### RE: Low Ridge Short Plat (SP-07-120)

The Kittitas County Community Development Services Department has determined that the Low Ridge Short Plat (SP-07-120) is a complete application and hereby grants **conditional preliminary approval** subject to the following conditions:

**Project:** Low Ridge Short Plat (SP-07-120)

LOW RIDGE SHORT PLAT

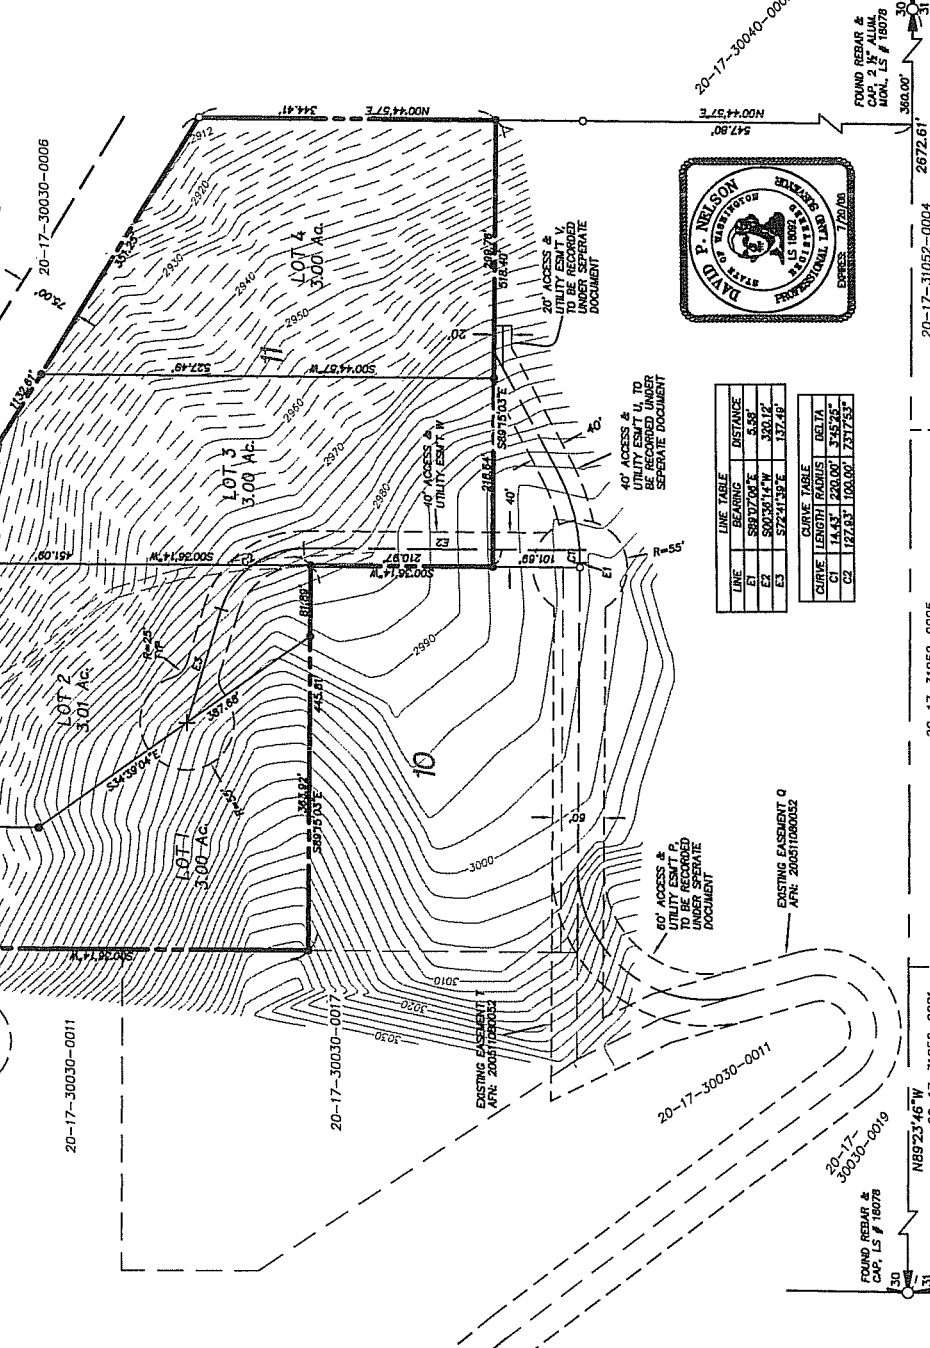
1. Both sheets of the final mylars shall reflect short plat number SP-07-120 and an accurate legal description shall be shown on the face of the final plat.

- B. As a condition of final plat approval, the previously recorded portion of easement "Q" connected to SR-970 at milepost 6.99 is no longer valid and is required to be removed. There shall be no access to the plat at milepost 6.99 on State Road-970.

- C. All access to the plat from SR-970 shall be at milepost 6.90, south of the Teanaway Road intersection (easement "R").
- D. The applicant will provide a safe location and passageway for a school bus stop. The local school district shall be consulted regarding the location and it shall be shown on the final mylars.

- a. Cul-de-sac design, reference AASHTO.
  - b. Contact the Fire Marshall regarding any additional cul-de-sac requirements.
4. Easement "W" Access to Lots 1, 2 & 3 and Easement "U" Access to Lot 4: It appears that access to lots 1, 2 & 3 of the Low Ridge Short Plat is via Easement "W" and access to lot 4 is via easement "U", as shown on the face of the plat. Per Kittitas County Road Standards, 9/6/05 edition, easement "W" and Easement "U" shall be improved to meet or exceed the requirements of a High-Density Private Road, serving no more than 14 tax parcels, from the cul-de-sac located between lots 1 & 2 of the Low Ridge Short Plat, south, to the cul-de-sac of the Big Ridge Short Plat located south of the southwest corner of lot 3 of the Low Ridge Short Plat. Easement "U" also originates from this cul-de-sac and heads northeast to serve lot 4 of the Low Ridge Short Plat.

- a. Access easements shall be a minimum of 40' wide. The roadway shall have a minimum width of 20', with 1' shoulders, for a total width of 22'.
  - b. Minimum centerline radius will be 60'.

- c. Surface requirement is for a minimum gravel surface depth of 6".
  - d. Maximum grade 8% flat, 12% rolling or mountainous.
  - e. Stopping site distance, reference AASHTO.
